### PRE-APPLICATION ENQUIRY

| REFERENCE NUMBER: | 20/30104/PREAPP  |
| ENQUIRY:          | PROPOSED 1.5 STOREY ECO-FRIENDLY DWELLING.                                 |
| LOCATION:         | LAND BETWEEN CONNEMARA AND NETHERFIELD, MICHAELSTOWE DRIVE, HARWICH, ESSEX |

Street Scene & Prop Site Plan

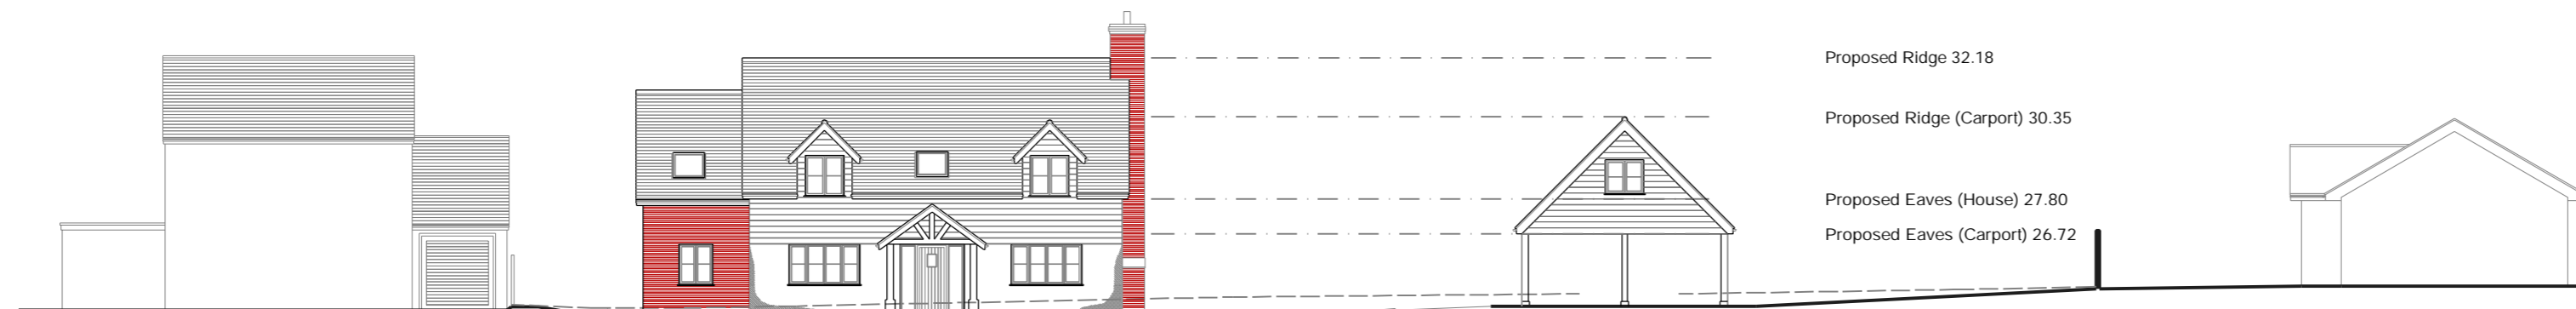
A block plan has been provided however it is hard to understand the layout or relationship of the dwelling on the site. It is suggested if a full application is submitted, elevations and floor plans will be required as well as a block plan demonstrating parking (in line with Essex Parking Standards), private amenity space, access and the proposal in relation to neighbouring amenities.

Essex Parking Standards state that there should be a minimum parking provision of 2 spaces for a dwelling with two or more bedrooms with parking spaces measuring 5.5 metres by 2.9 metres or garages should measure 7 metres by 3 metres. A block plan will need to be provided when submitting a full application demonstrating that the proposed dwelling can achieve sufficient parking in line with Essex Parking Standards.

**Proposed Floor Plans**

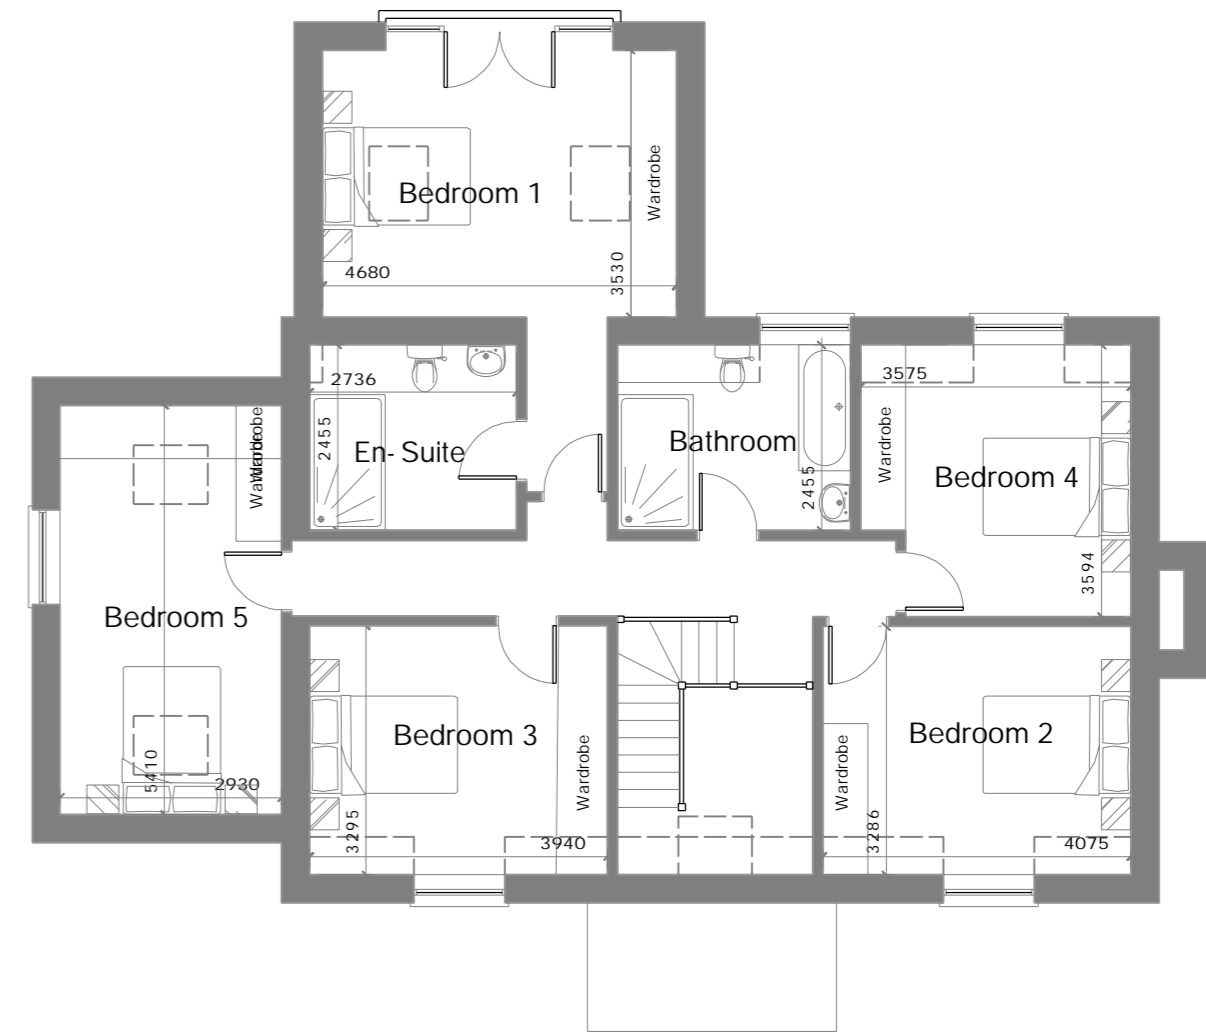
No indication of the number of bedrooms has been provided and therefore the proposed dwelling would need to comply with Policy HG9 of the Tendring District Local Plan (2007).

Within the cover letter accompanying this pre application, it is stated that the proposal will incorporate solar panels and the option to run a ground source heat pump. When submitting a full application, please submit details of the above as well as identifying the proposed works on the block plan, floor plan and elevations.
